**From:** Nayan Gandhi <nayan.gandhi@rpsgroup.com>  
**Sent:** 16 December 2020 1:56 PM  
**To:** Mandip Malhotra  
**Cc:** stuart; Rebecca Lo; Craig Shanley; Karen Price  
**Subject:** The Gramophone, Hayes - Overlooking  
**Attachments:** GRM-AI-XX-ZZ-DR-A-302[P10] - Proposed East and South Elevation.pdf; GRM-SK-Proposed Massing Amendments.pdf; Proposed East and South Elevation - Comparison markup.pdf; Facing boundary distances\_v1.pdf; GRM-AI-XX-ZZ-DR-A-211[P09] - Proposed Level 01 and 02 Plan.pdf

Proposed Level 01 and 02 Plan

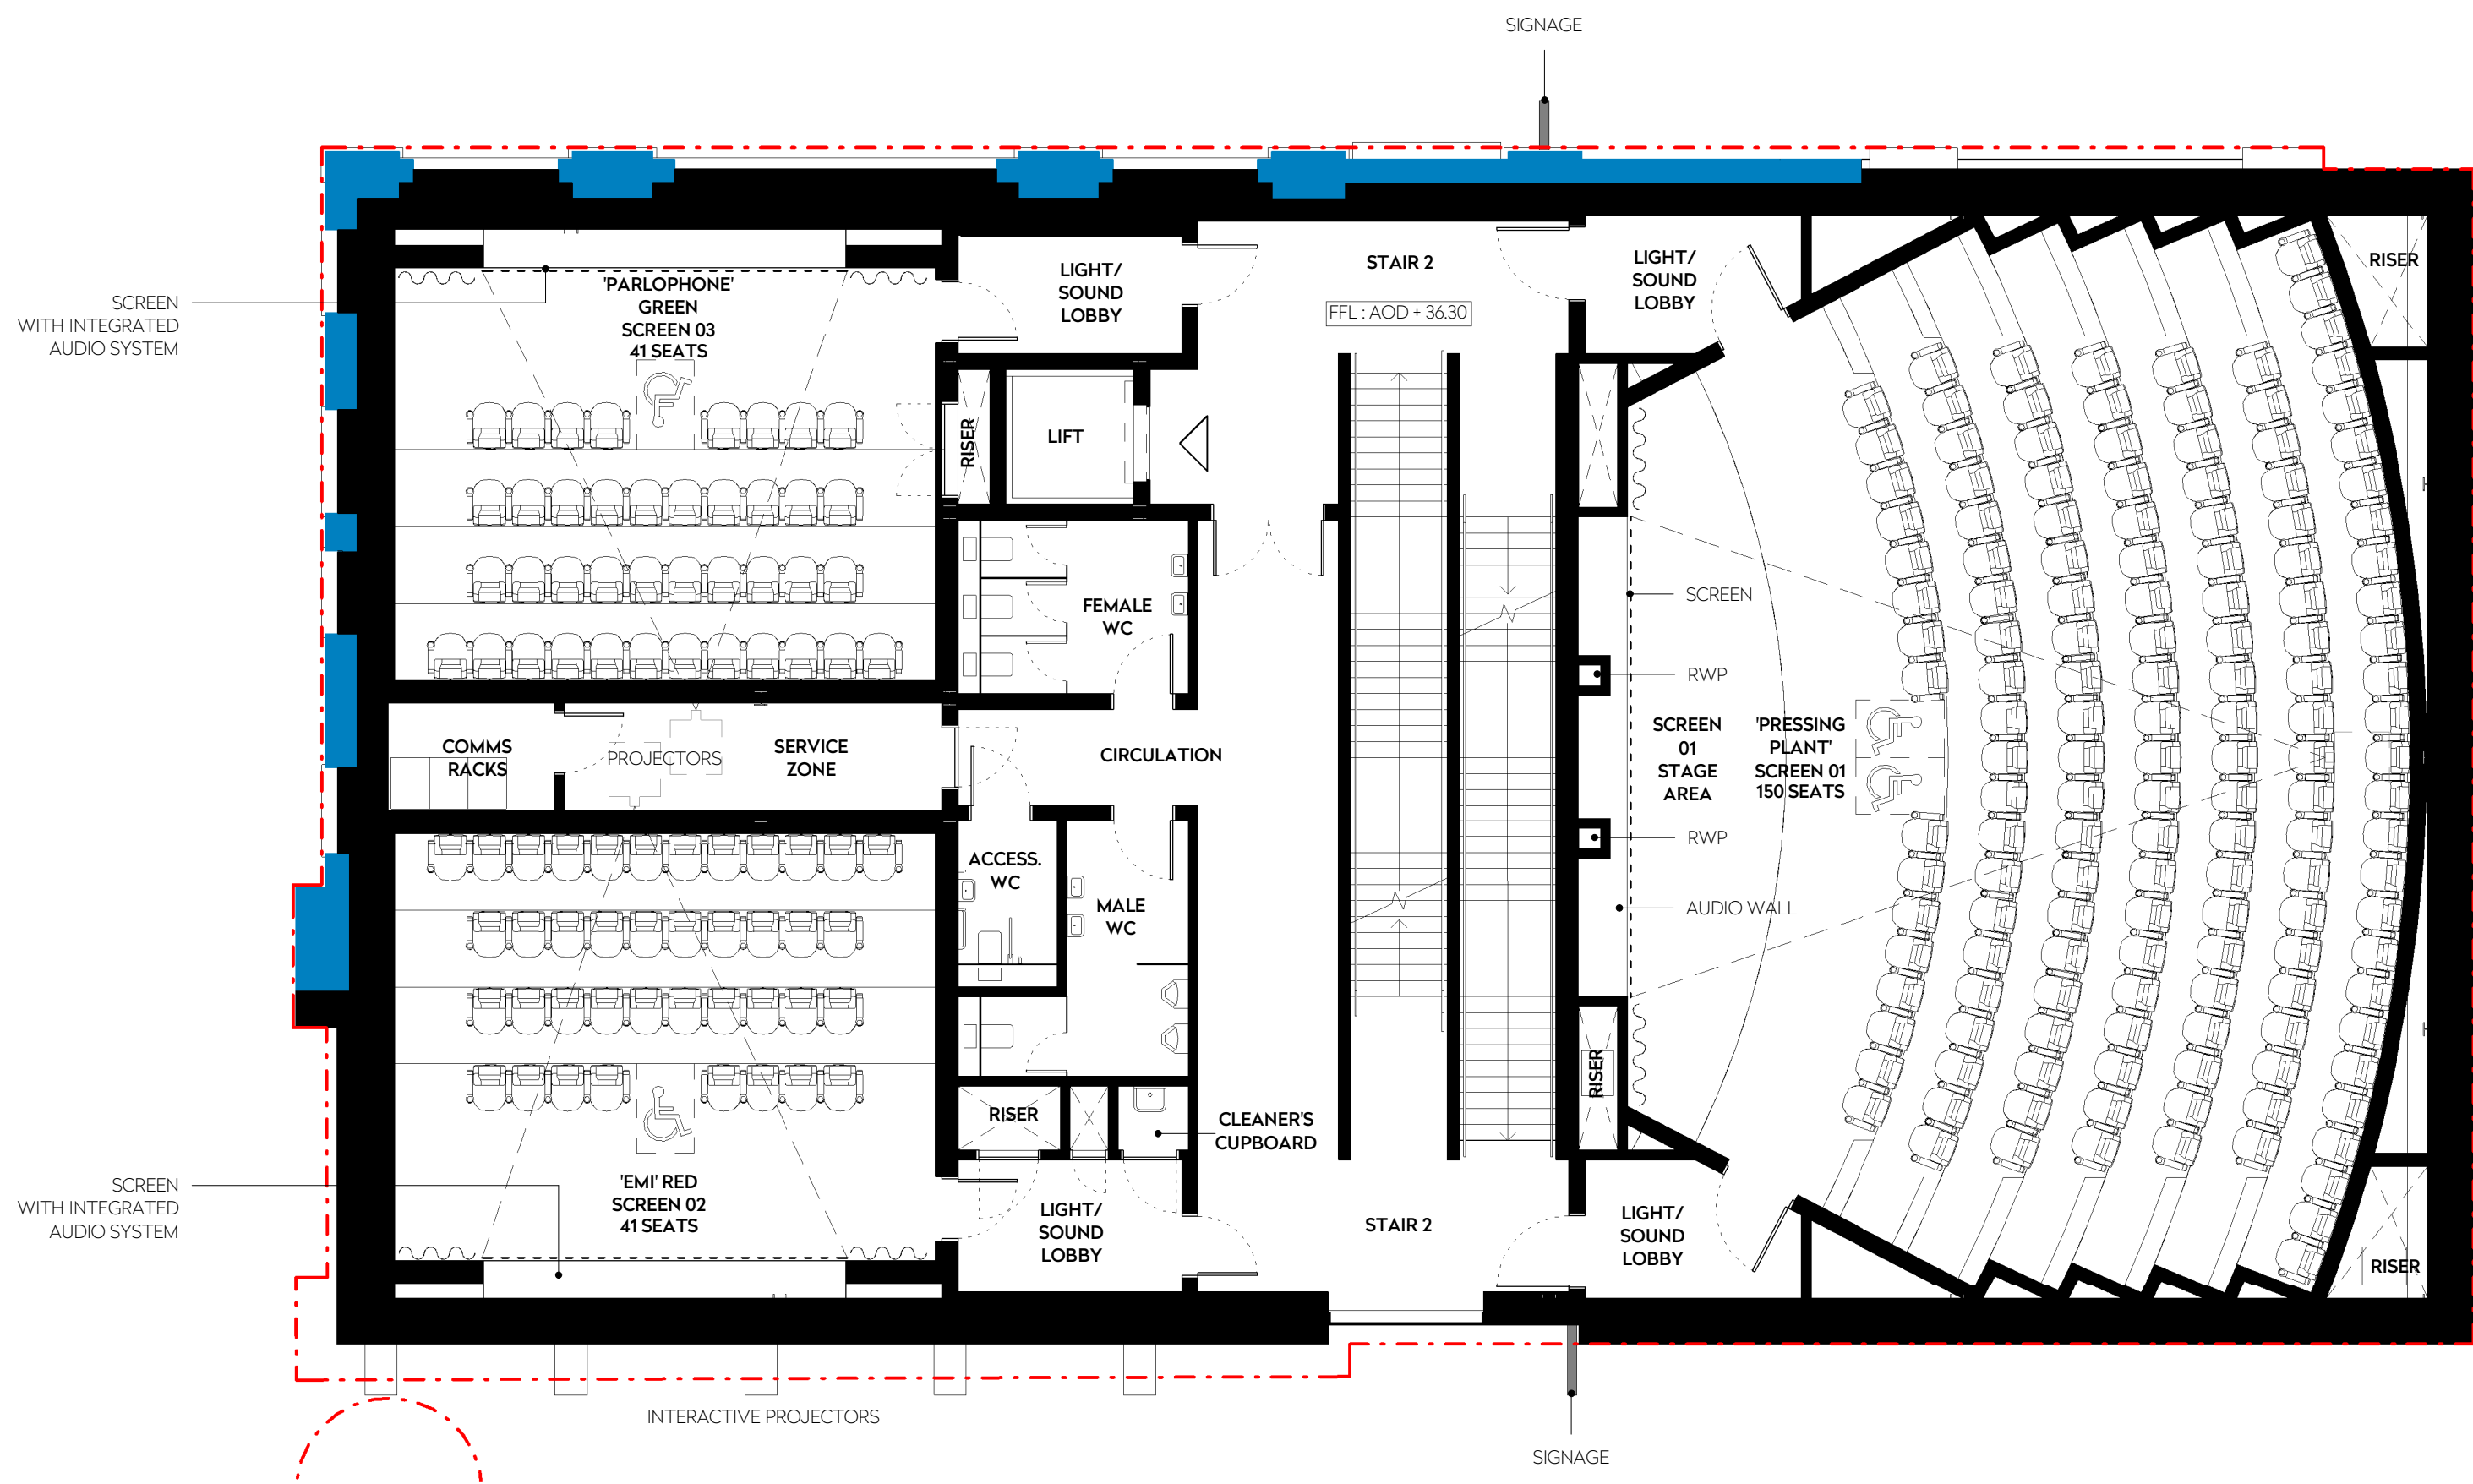
We now find ourselves assessing the current proposal, which increases the building height, therefore resulting in a more dominant form of development for the future occupiers of the Crest Nicholson block, the daylight and sunlight report identifies further losses to these apartments (which i note we have previously advised is not a standalone reason for refusal) which i note that you have not disputed. This is then further exacerbated by the inclusion of an additional window within the facade facing the Crest Nicholson block (which serves your proposed Listening Cafe)

which has raises concerns of overlooking and further diminishes the residential amenity of the Crest Nicholson future occupiers.

- Proposed Level 01 and 02 Plan drawing (Architecture Initiative Drawing No GRM-AI-XX-ZZ-DR-A-211, Rev P9)
- Proposed East and South Elevation drawing (Architecture Initiative Drawing No GRM-AI-XX-ZZ-DR-A-302, Rev P10)

These show that the windows you have concerns about have been altered in shape and size and will be obscure/etched glass, which will eliminate any privacy/overlooking issues, and yet at the same time allow for an element of natural light into the building and also retain interest along this elevation. Indeed, etching/obscuring is a standard way of addressing this issue when buildings are perceived to be too close together, which no doubt you have come across before. For clarity, with these changes, we would also achieve an 84% reduction in the amount of glazing facing the residential block, and any windows would be obscured at second floor level.

Proposed South Elevation

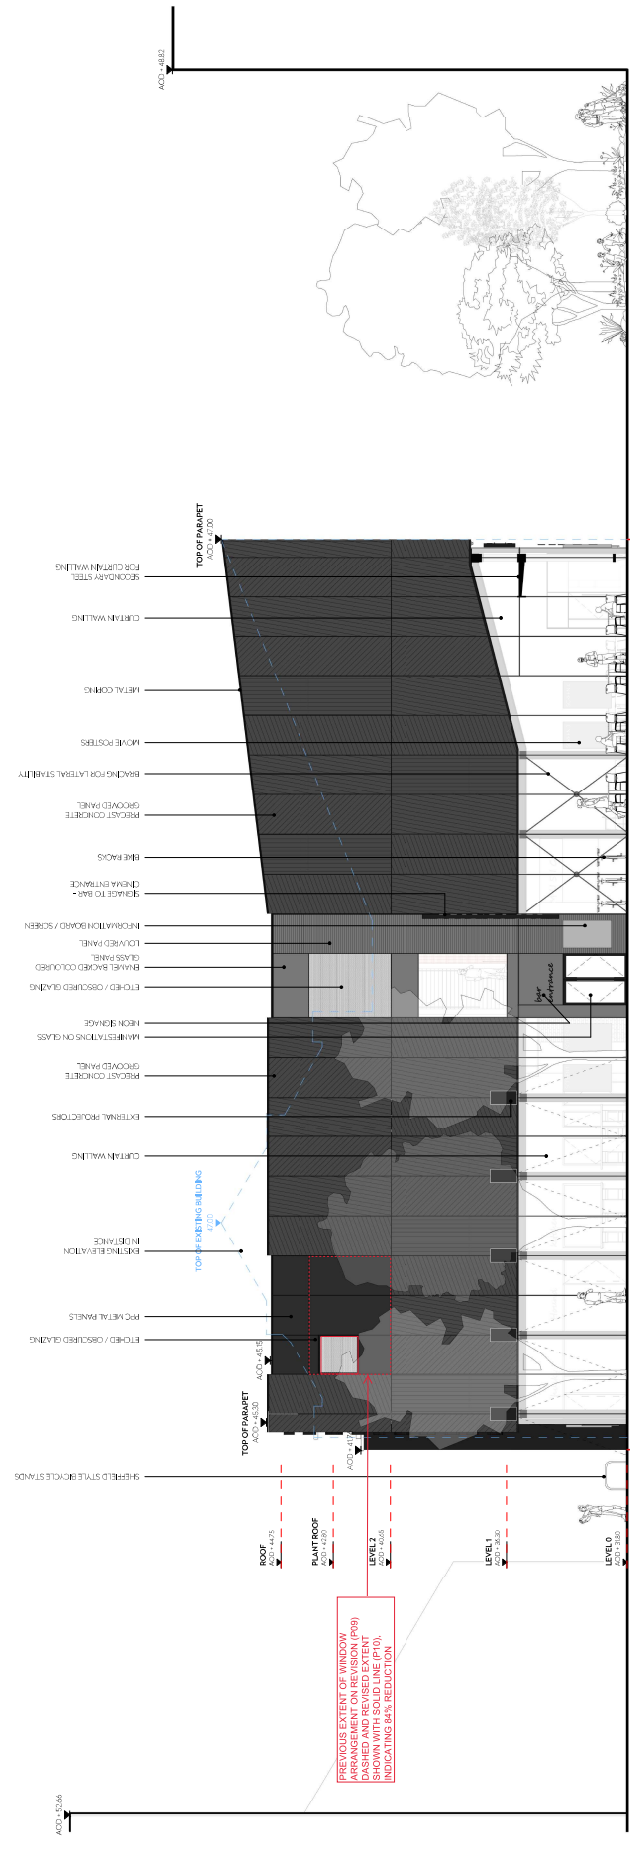
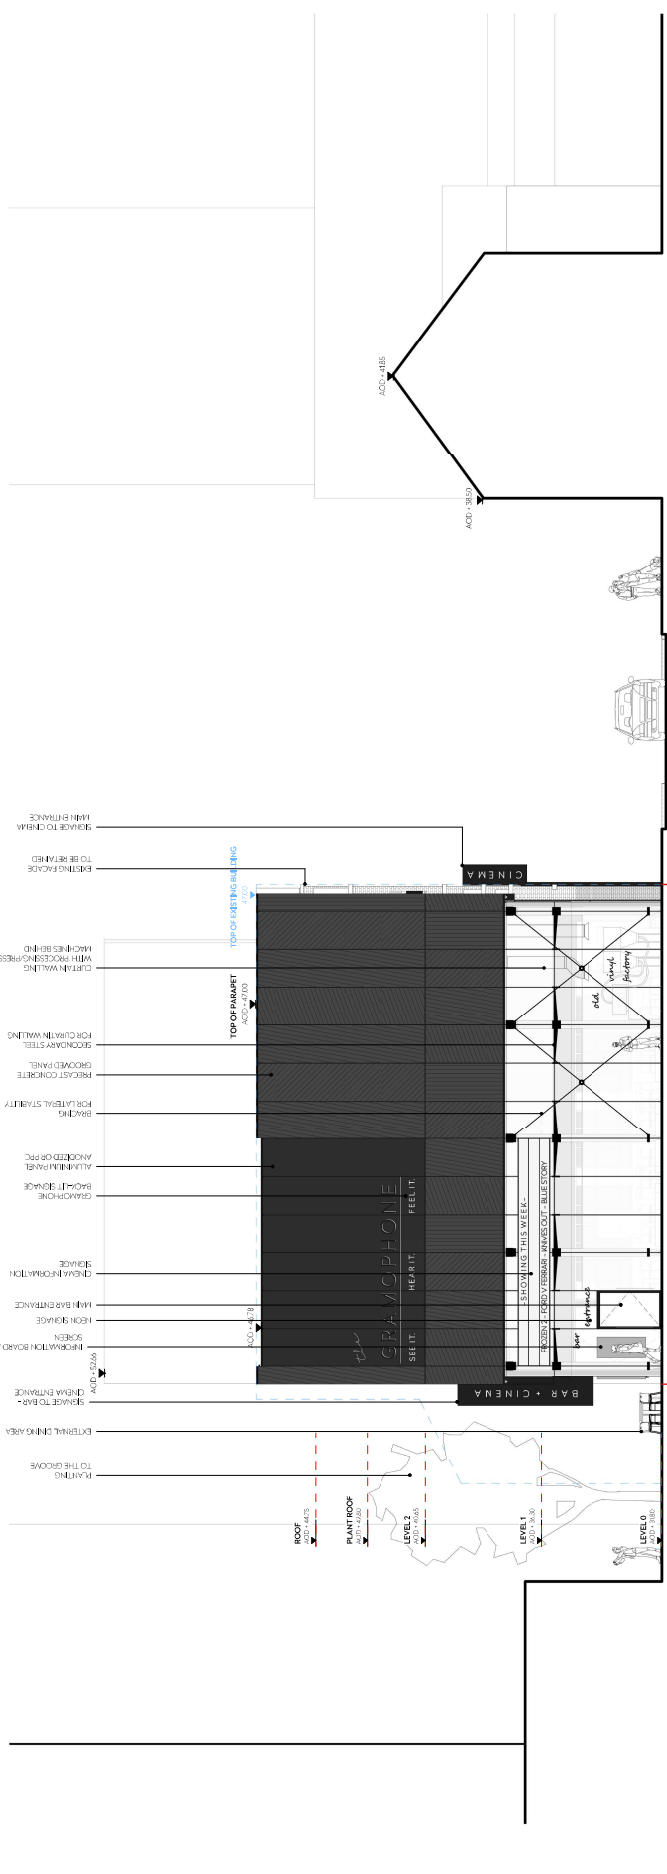
Obscure glazing to the window does not overcome all concerns, the perception of overlooking remains which coupled with loss of light and an overbearing impact from the developments increased height does tip this proposal into an area where it is not acceptable and the on balance arguments that have been made move to reasons for refusal due to the cumulative impacts.

In terms of your request to remove the glazing in the Listening Café and the glazing in the communal staircore above the entrance from the Groove, as already mentioned the permitted scheme has a full glazed elevation where the entrance area is and therefore obviously this could be implemented. Crest Nicholson, the owner of the residential block opposite the Pressing Plant, submitted the permitted drawings with the full glazing and therefore could not have had any concerns and they have not made any objections to our revised proposals. Furthermore, the Council have not provided any calculations as to how they have deduced the effect of light spillage on any of the residential rooms. For ease I have attached the permitted and proposed elevations.

Thank you for your time yesterday. You agreed at the meeting that if we turned windows serving the Listening Café into high level windows and etched/obscured all windows facing the Machine Store Residential Block A, this would address your concerns regarding the provision of those windows at second floor level.

The reduction in glazing serving the Listening Café was made for design reasons, as small square window styles are found in the established pattern of windows on other facades of the building, so we thought it would be best to reflect this on the new elevation as well, instead of three high-level windows as suggested at our meeting. However, if you prefer three high-level windows instead (to reflect the extent of glazing proposed previously), then please do let us know and we can re-introduce these, albeit as high-level obscure windows.

- Another version of the 'Proposed East and South Elevation' drawing (Architecture Initiative Drawing No GRM-AI-XX-ZZ-DR-A-302, Rev P10) which includes an outline reference of the previous windows proposed at the Listening Café, so you can understand the changes that have been made.
